## **FIRE RISK MANAGEMENT, INC**

# **Memo Report**

**Subject: Fire Protection and Life Safety Systems Review; ICW Renovation of the Westin Eastland Park Hotel in Portland, ME**

**GROUND & 2ND LEVEL LIFE SAFETY PLANS**

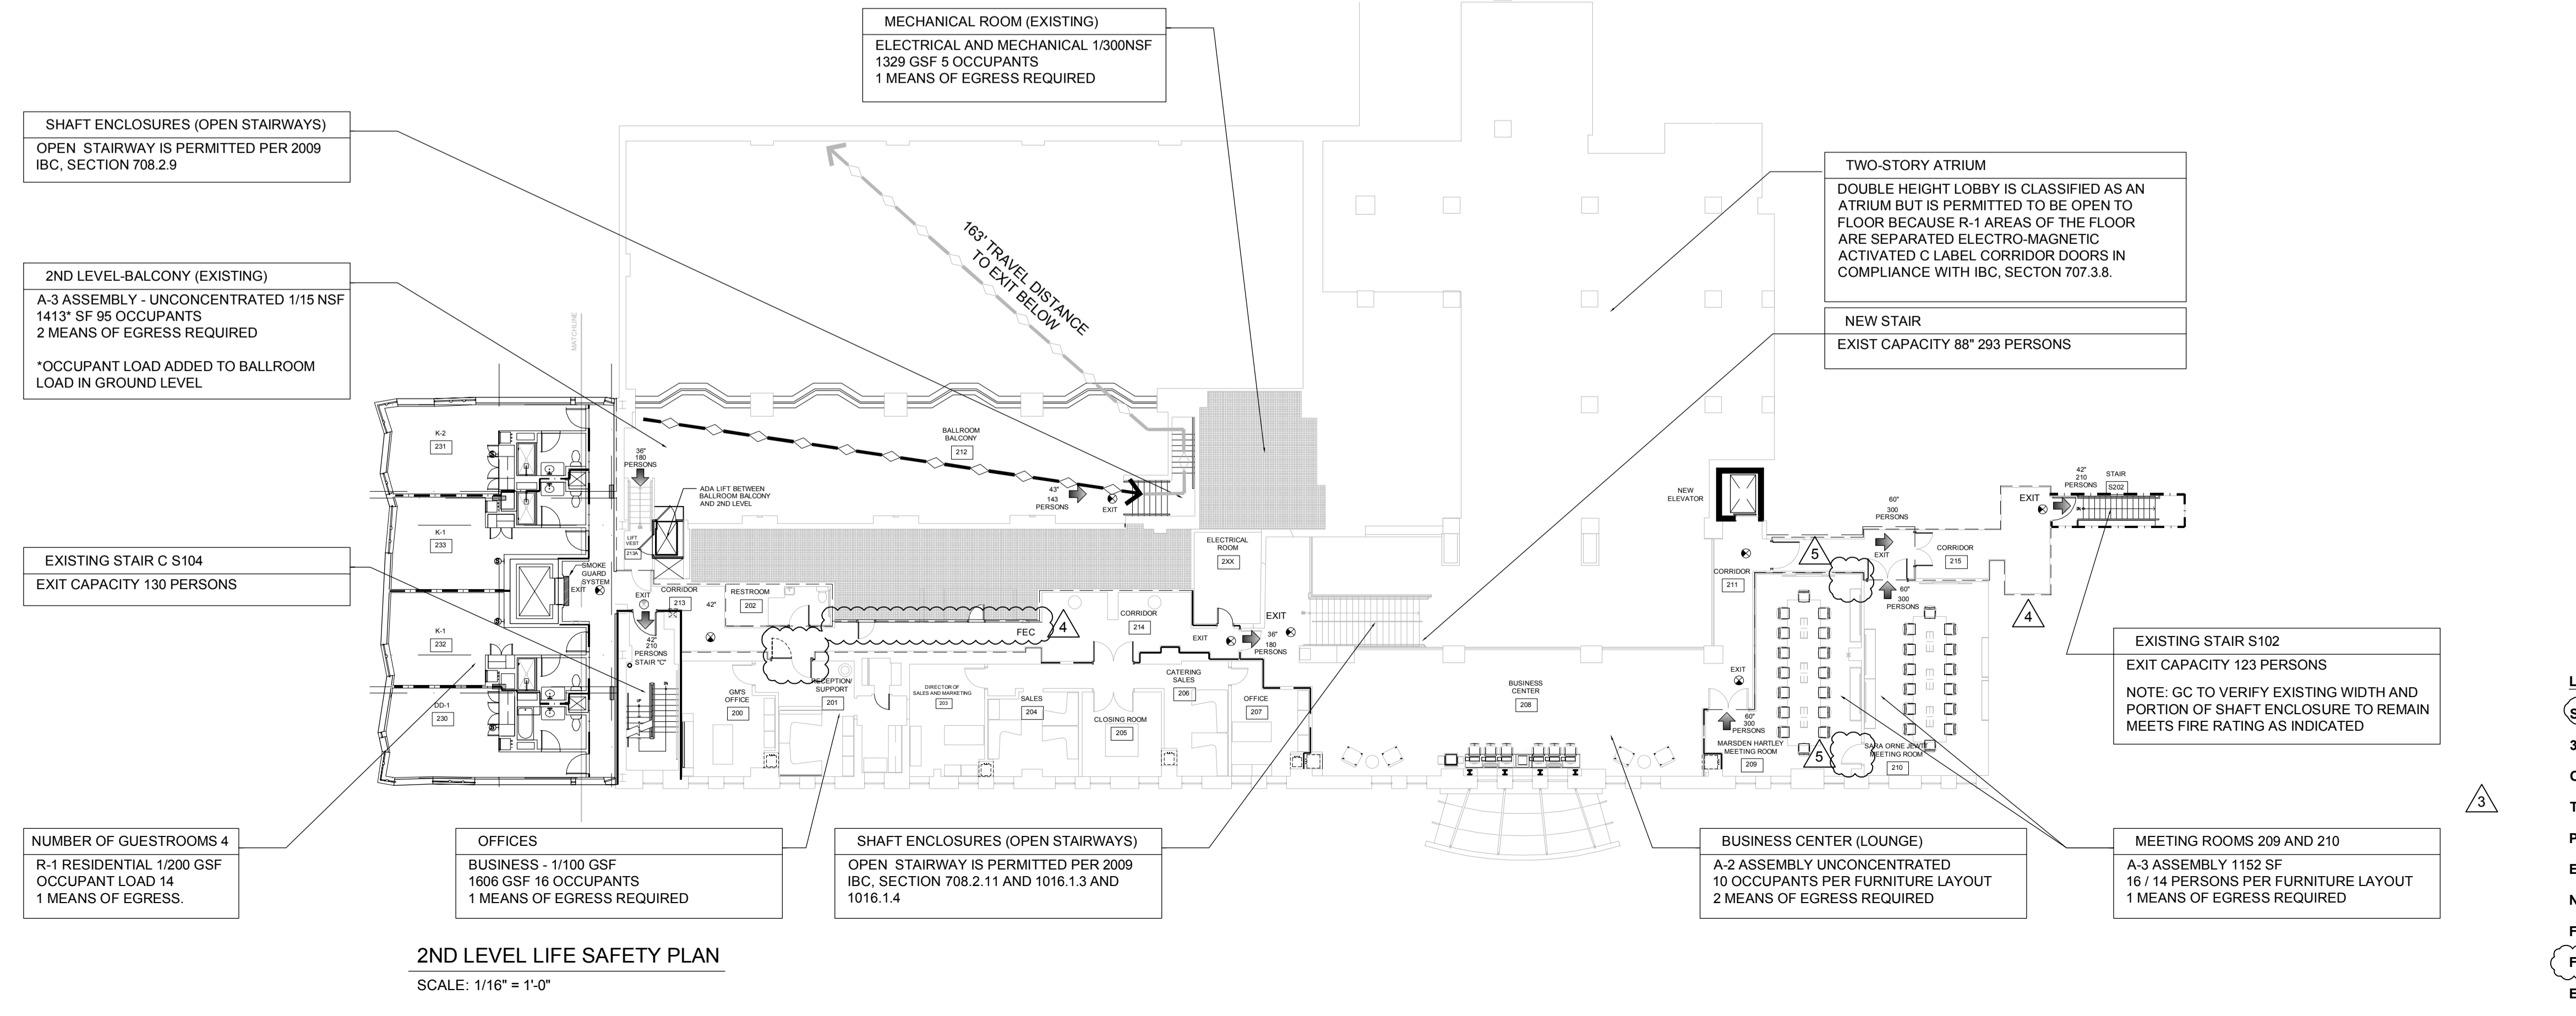
1. Need to add an exit sign within the “Prefunction” area at the 1<sup>st</sup> floor; adjacent to the exit door leading to the exterior, adjacent to High St.
2. Need to add an exit sign at the end of the ramp/corridor that acts as the second means of egress from the Junior Ballroom, connecting this room to the corridor adjacent to the ADR.
3. Need to relocate the exit sign that is adjacent to the Kitchen’s exit door and that leads to the service corridor for the Ballroom. This corridor also acts as a second means of egress from the Hawthorne (conference) Room and the current location of the exit sign is confusing. It should be moved to the center of the corridor and be

designed such that it can be viewed from both the Kitchen side and the corridor from the Hawthorne Room; with arrows (chevrons) pointing in the direction of the Ballroom.

As soon as each item was identified during this final survey, IDC took immediate action to implement the necessary corrective actions.

14TH FLOOR LIFE SAFETY PLAN  
SCALE: 1/16" = 1'-0"

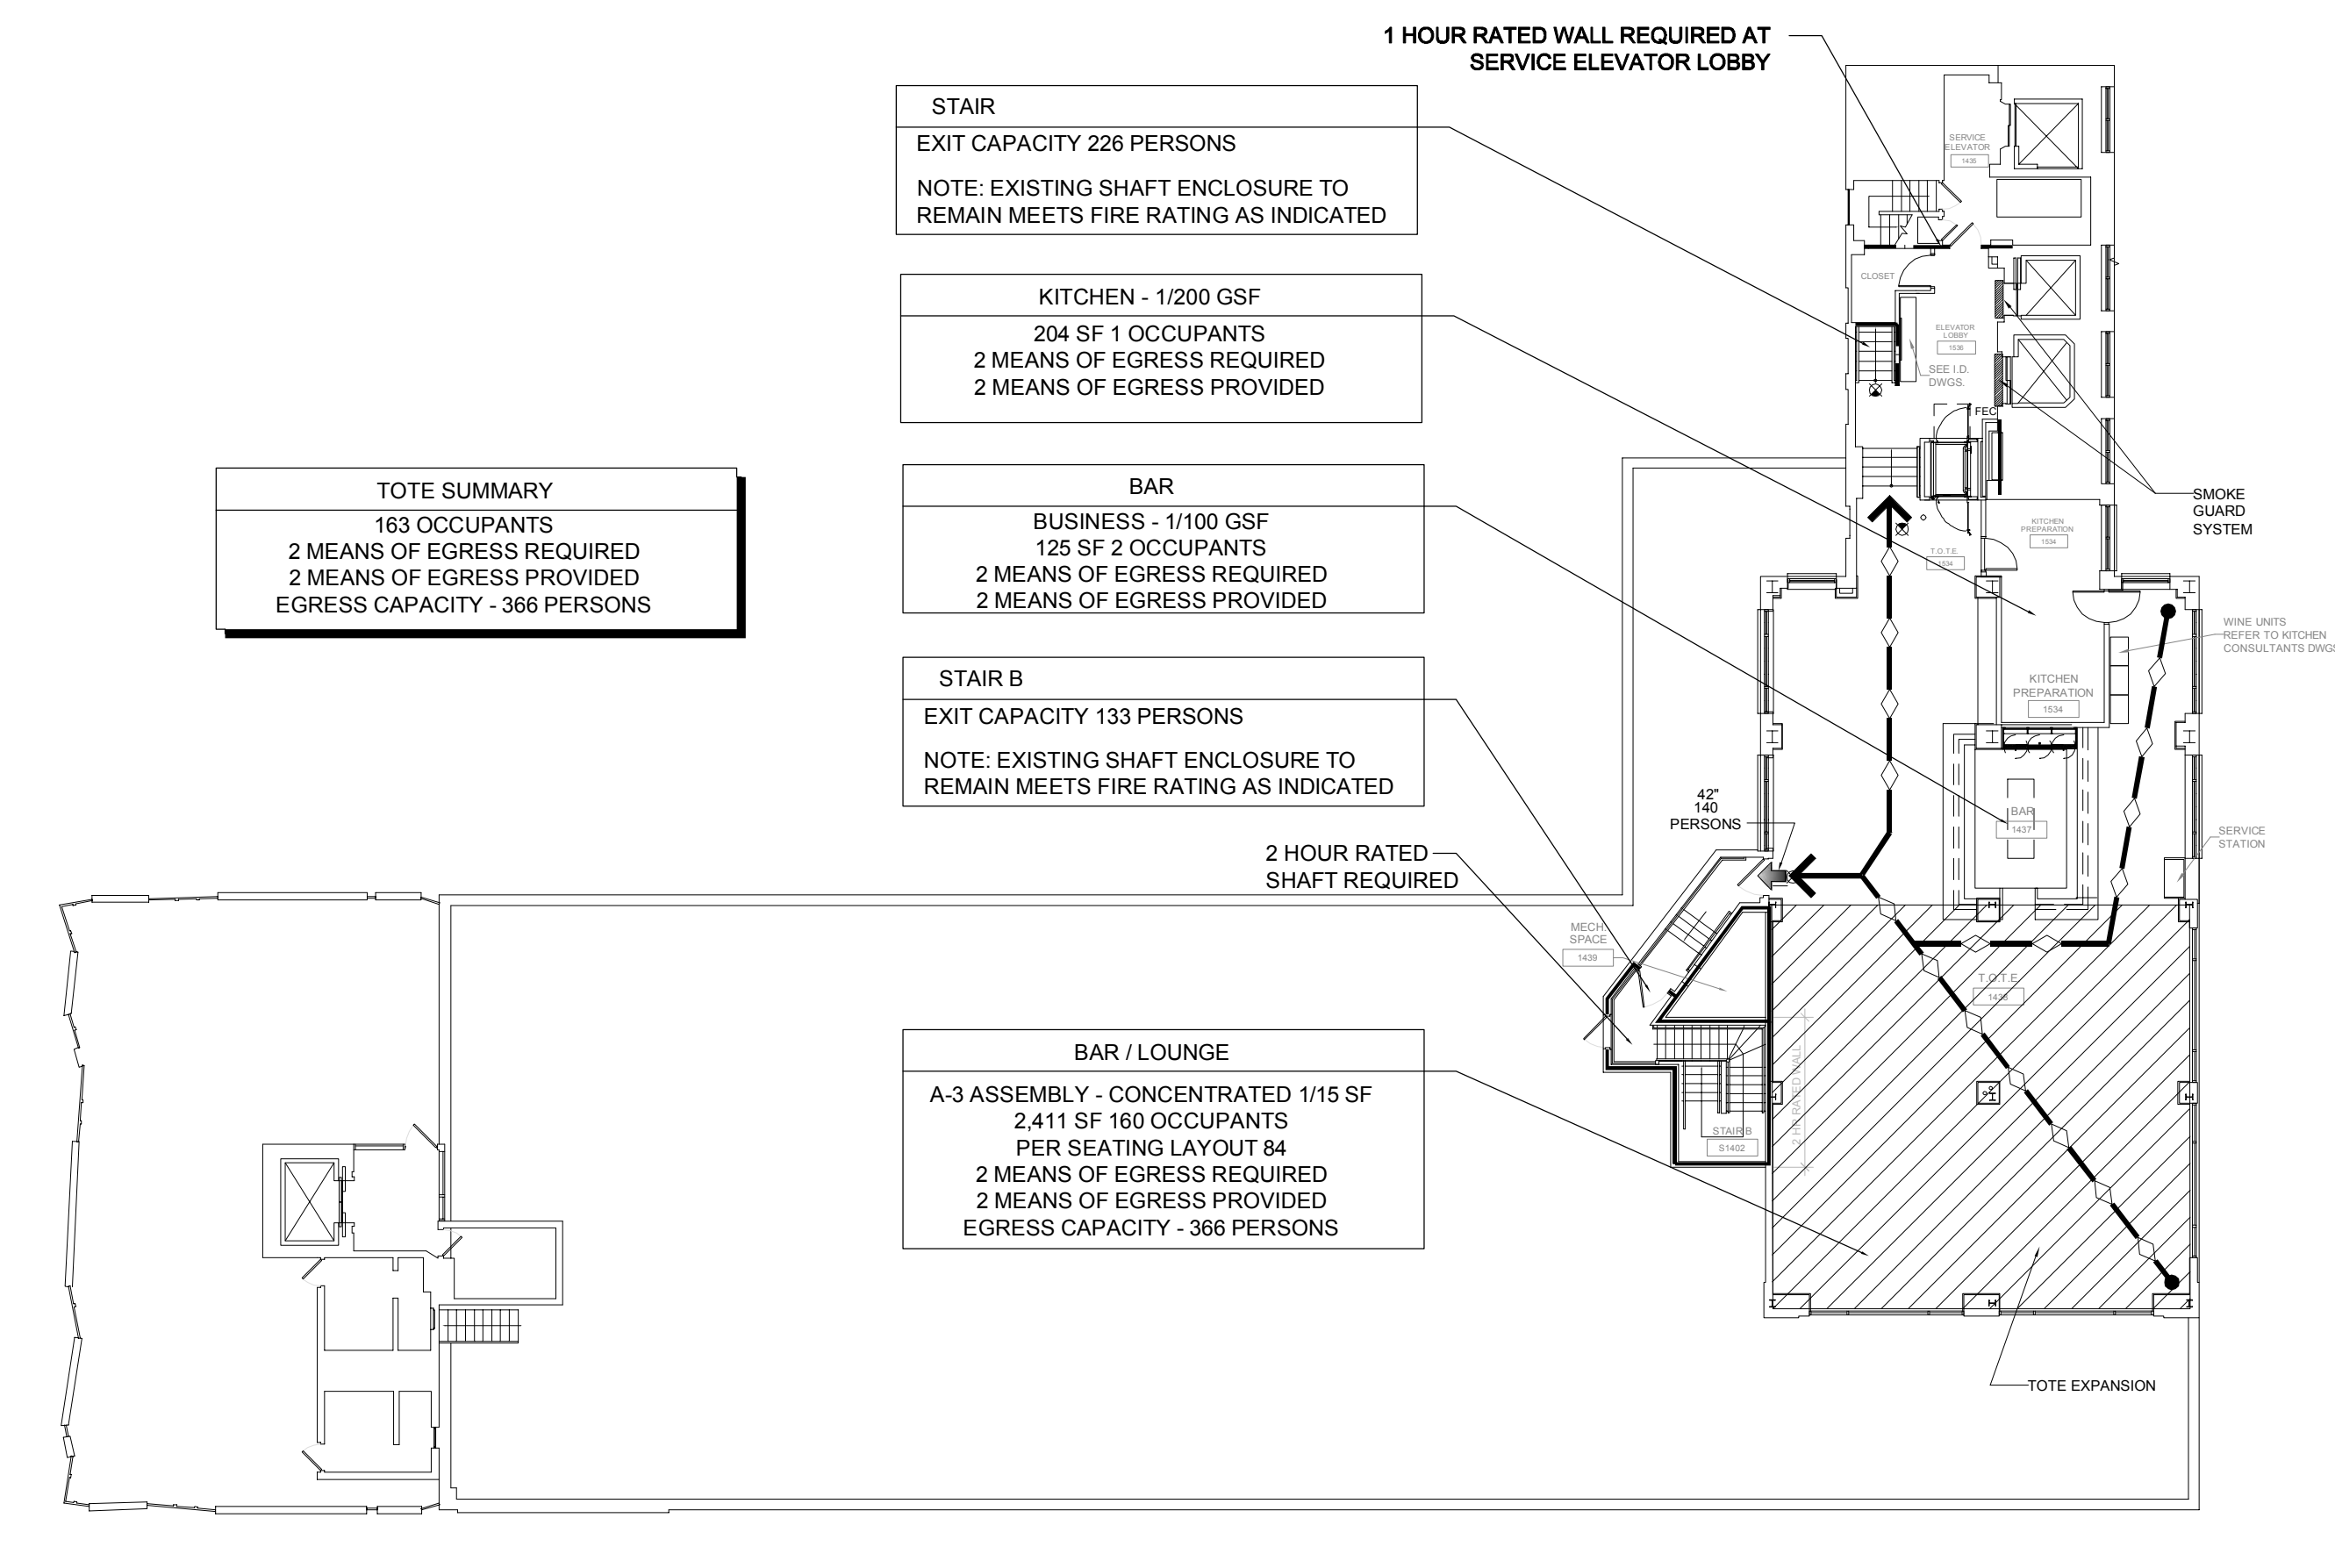
4. Provide continuity of the railing design for the stairway leading from the TOTE to the 14<sup>th</sup> floor to ensure that no gap in the railing exceeds 4 inches.
5. Provide continuity of the railing design at the 1<sup>st</sup> floor level of Stair B to ensure no gap in the railing exceeds 4 inches.
6. An exit sign should be added to the inside of the 1<sup>st</sup> floor door in Stair B to highlight the fact that this is the level of exit discharge for this stair.
